FORMAL OBJECTION TO PLANNING APPLICATION

Weston Parish Council

Re: Planning Application – H22-0566-26

Proposed Free Range Egg Production Unit, Delgate Bank, Weston

Drawing
Elevations and Plan View A1

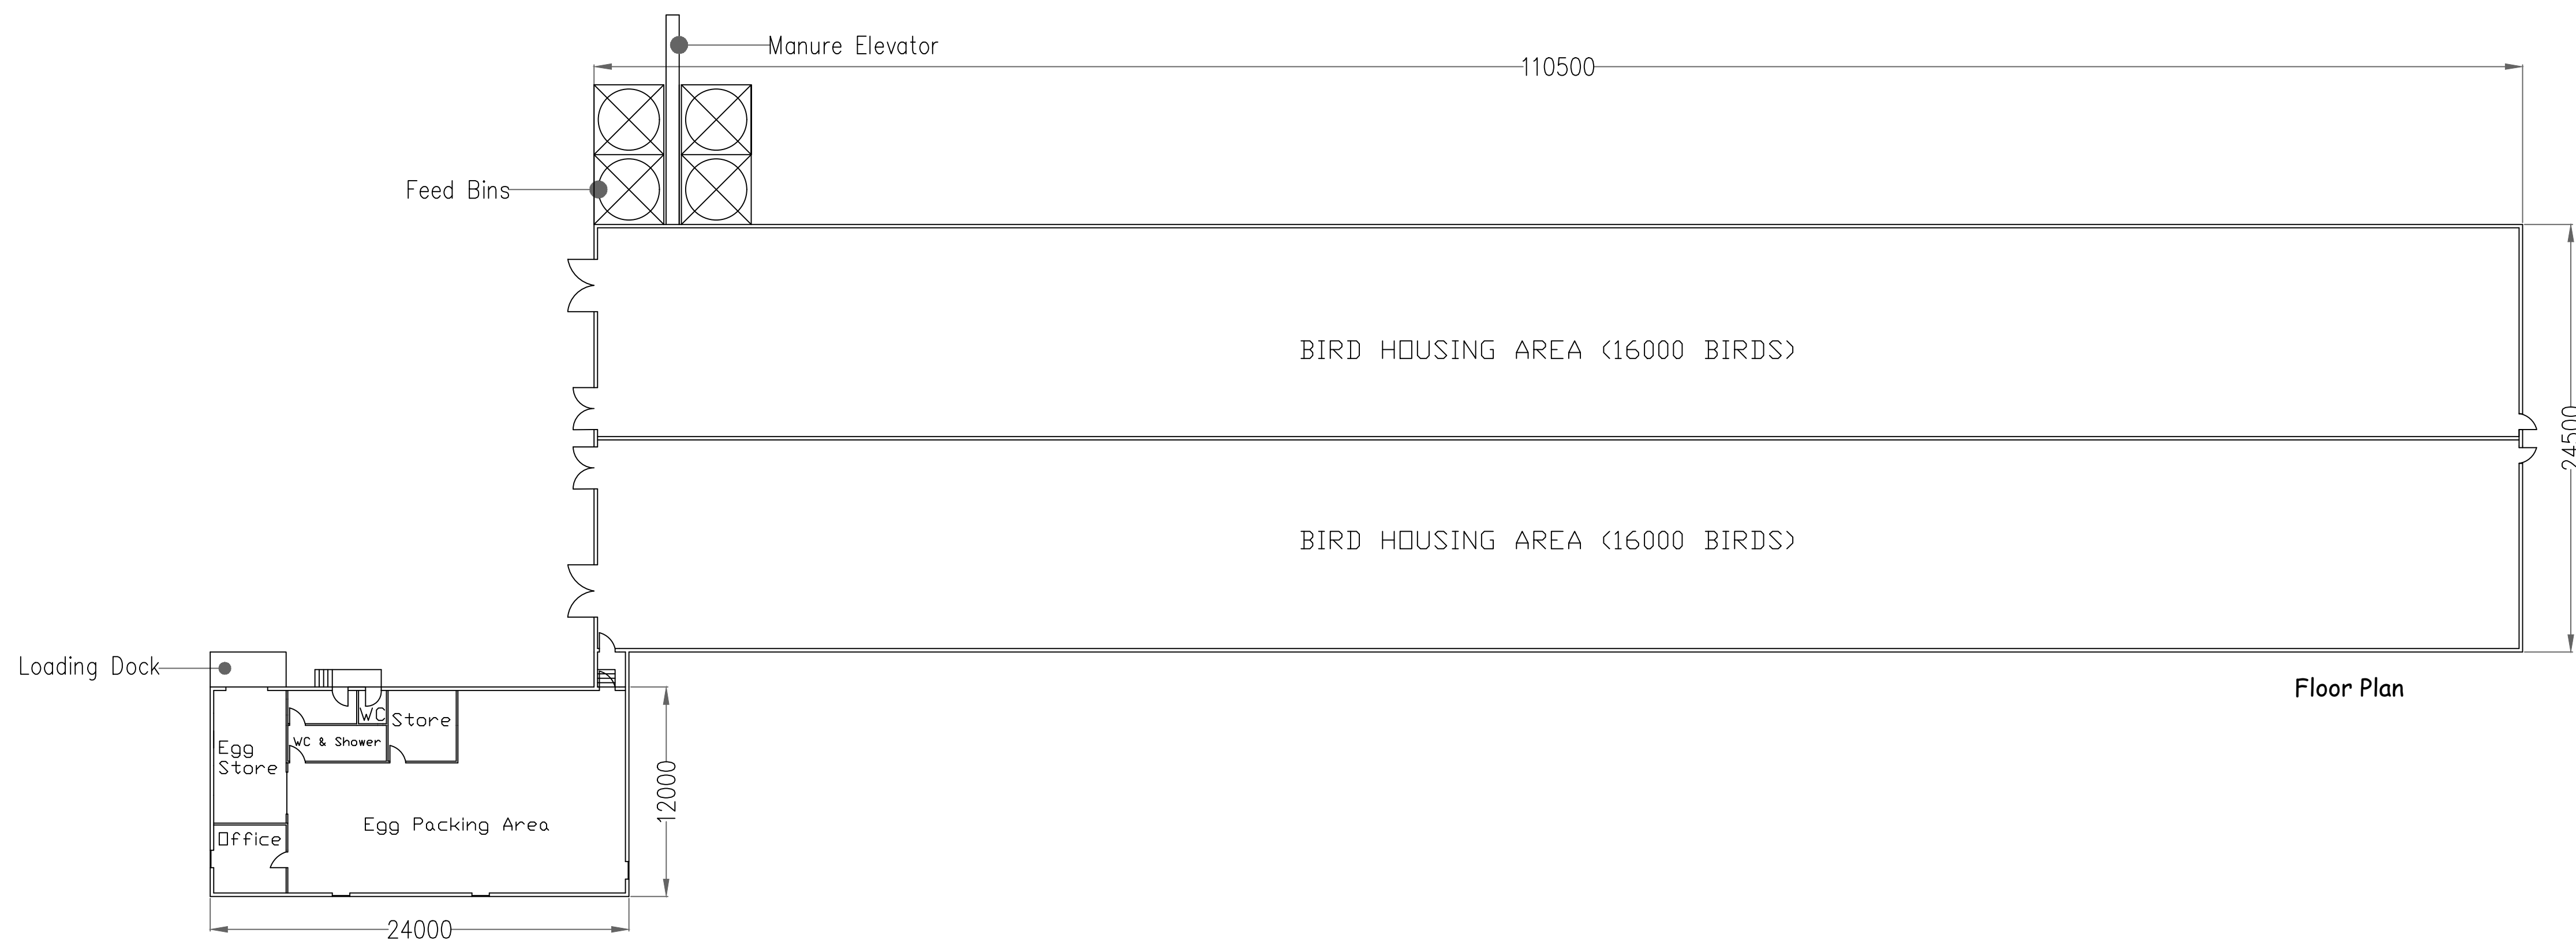
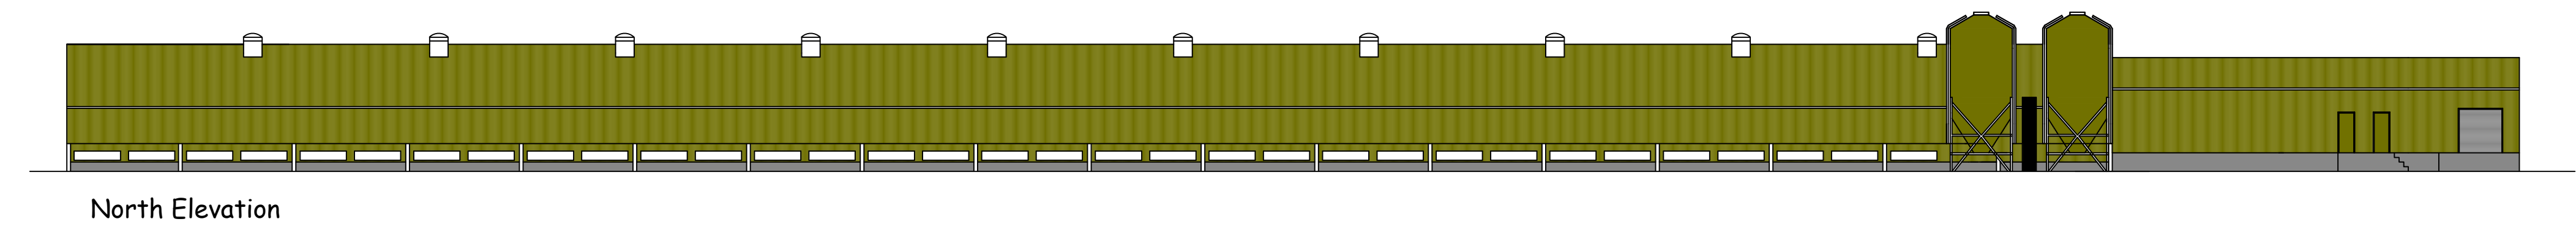
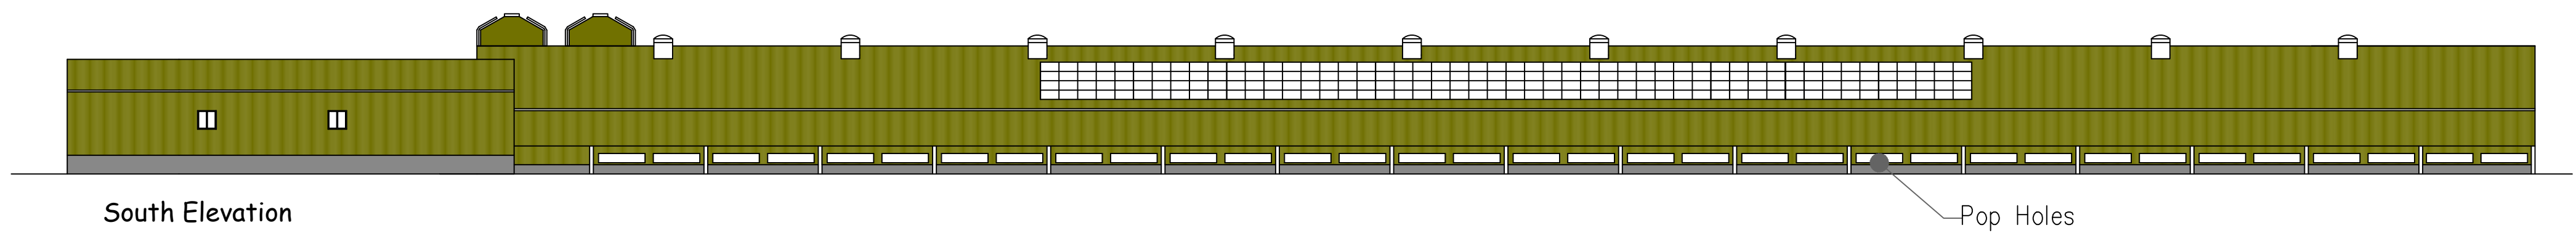
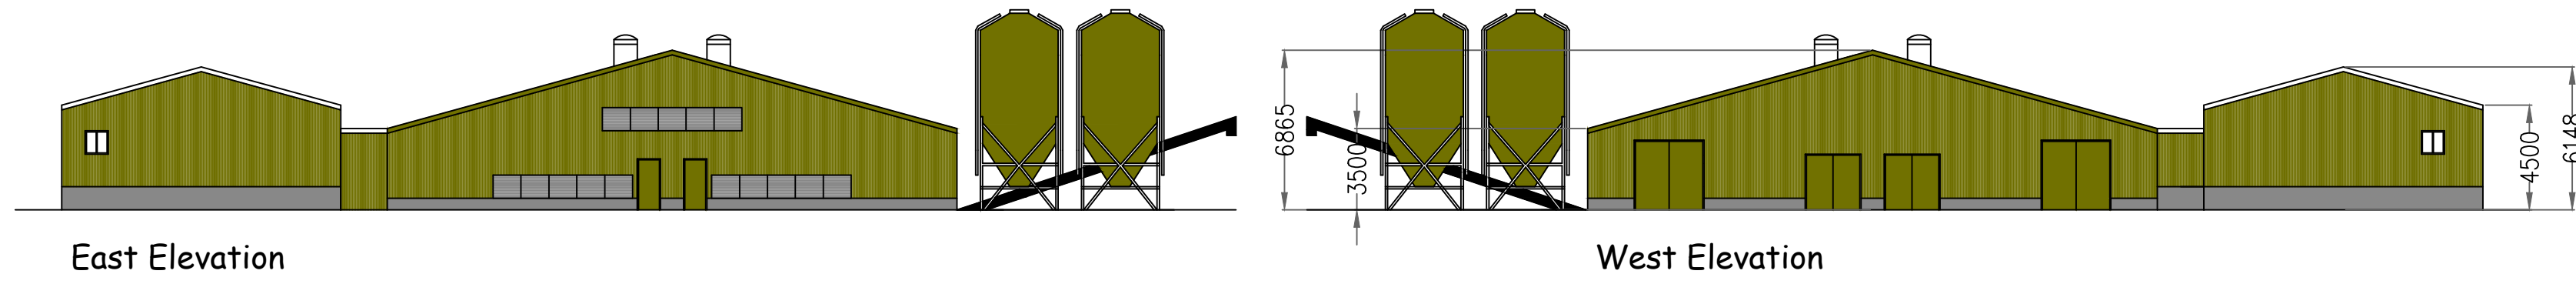
The proposed building measures approximately 110.5 metres long, 24.5 metres wide and approximately 8.8 metres high to the ridge, creating a building of almost **2,700m²**.

The Parish Council considers that conclusion to be unsupported.

The building:

- occupies an isolated position within an open Fenland landscape;

- will be visible over considerable distances;
- is substantially larger than surrounding agricultural buildings;
- relies upon landscaping that will take many years to become effective;
- sits alongside existing and proposed electricity transmission infrastructure.

Proposed Access Design - Scale 1 : 250

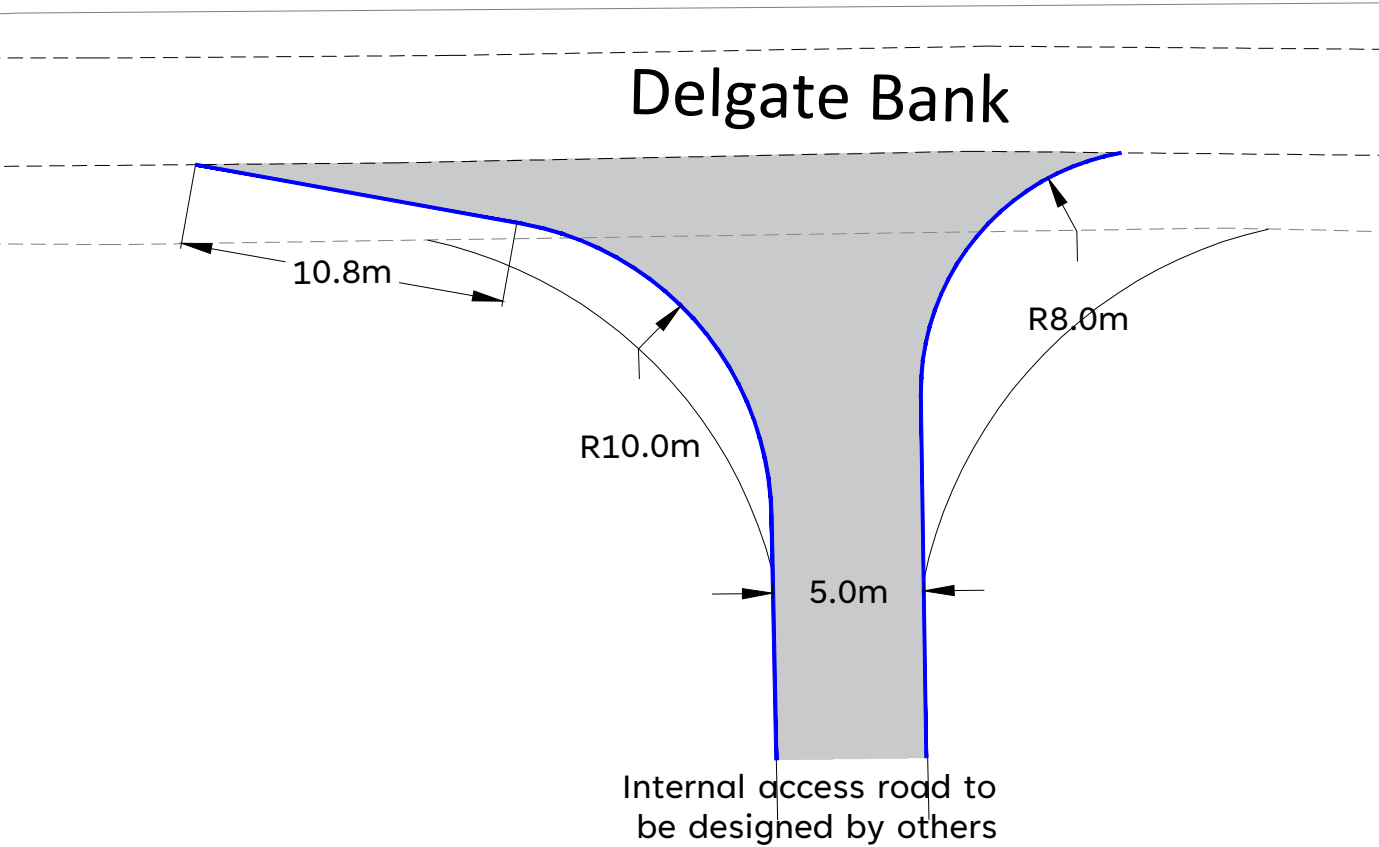
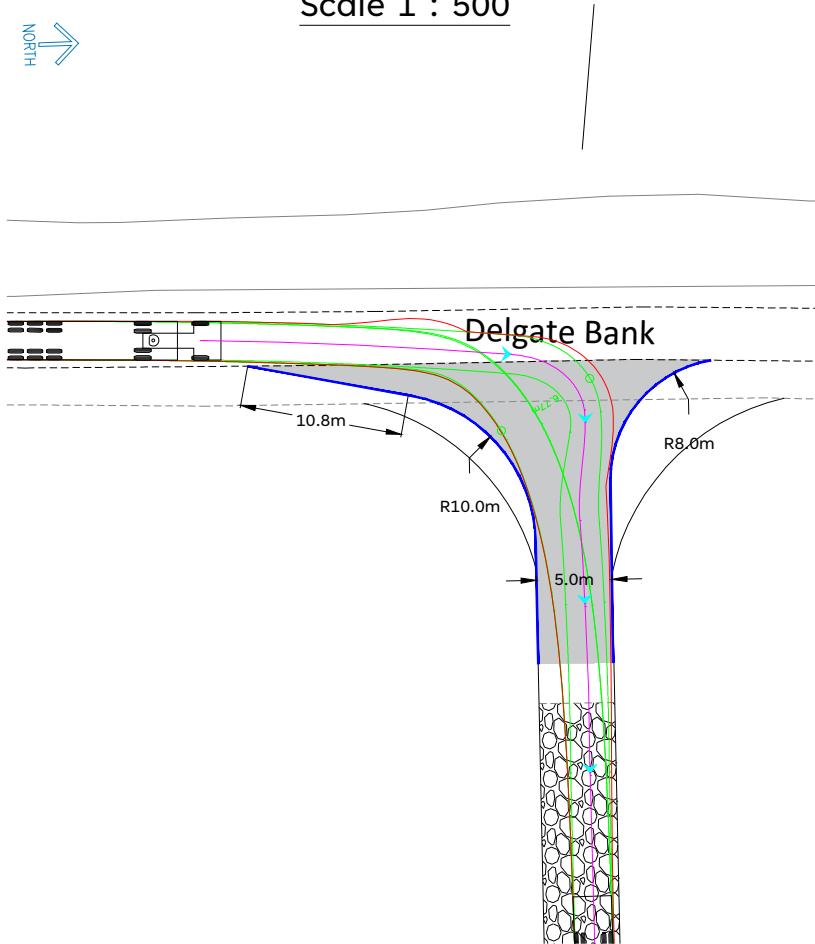
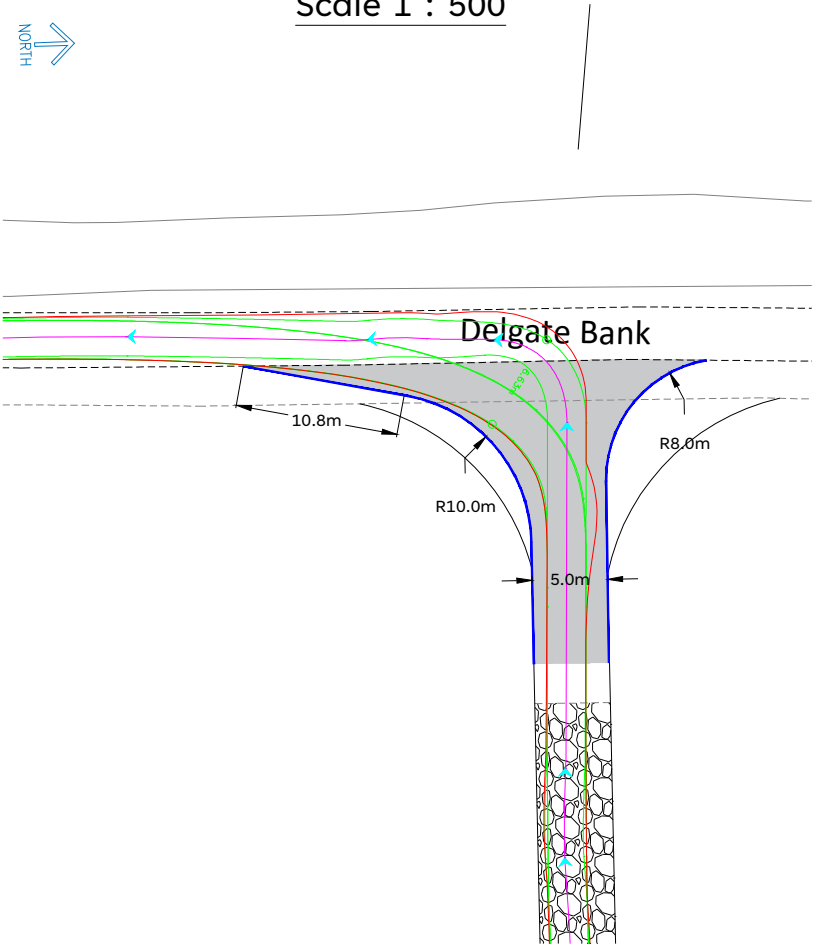
Delgate Bank is approximately 3.2 metres wide in places and functions as a single-track road not 3.7 metres as stated in the application. It is adjacent to the Delgate Drain with no identified passing places.

The Transport Statement does not adequately assess:

- opposing HGV movements;
- agricultural machinery;
- reversing distances;
- passing opportunities;
- restrictions caused by Delgate Drain and mature hedgerows.

Appendix 3 – Collision Plot

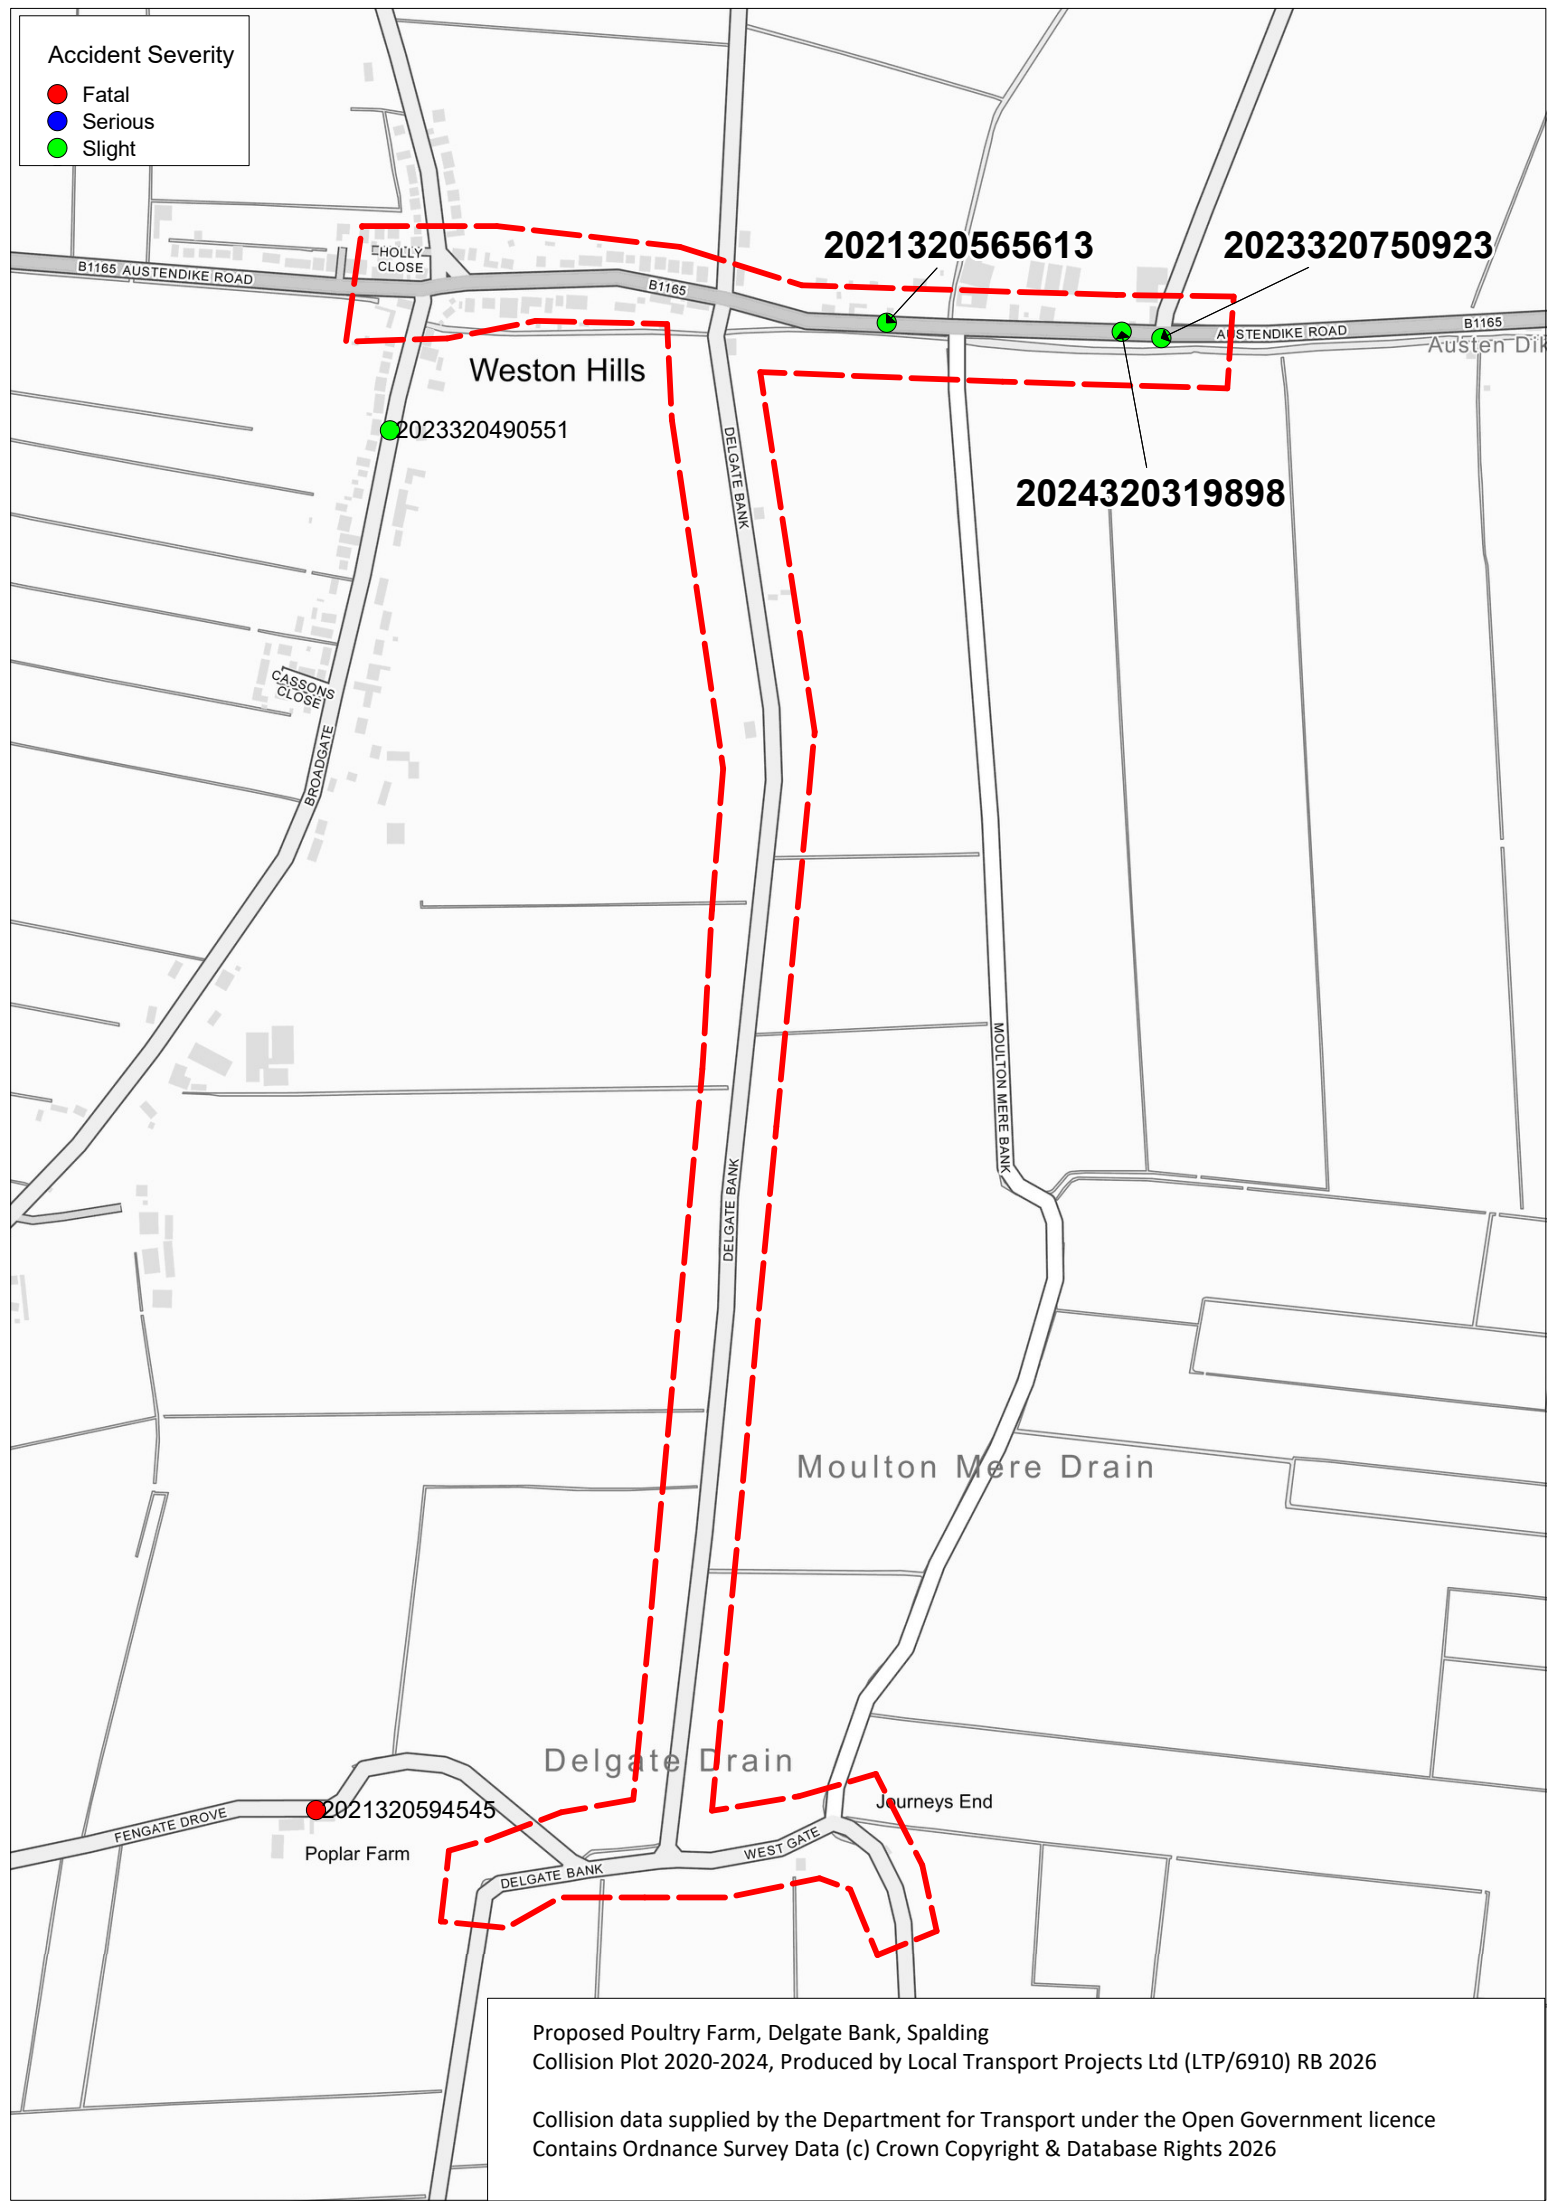
The collision assessment appears incomplete.

Known police-attended accidents are omitted, including:

- Delgate Crossroads – 27 October 2024 (three vehicles);
- Austendyke Road – 14 December 2024 (two vehicles).

If the collision dataset is incomplete, the conclusions regarding highway safety are unreliable nor do they reflect the roads identified as the main route i.e. Moulton Chapel Rd and Fengate Drove/Delgate Bank and Westgate. This route is marked at the Fengate Drove entrance as Unsuitable for HGV's.
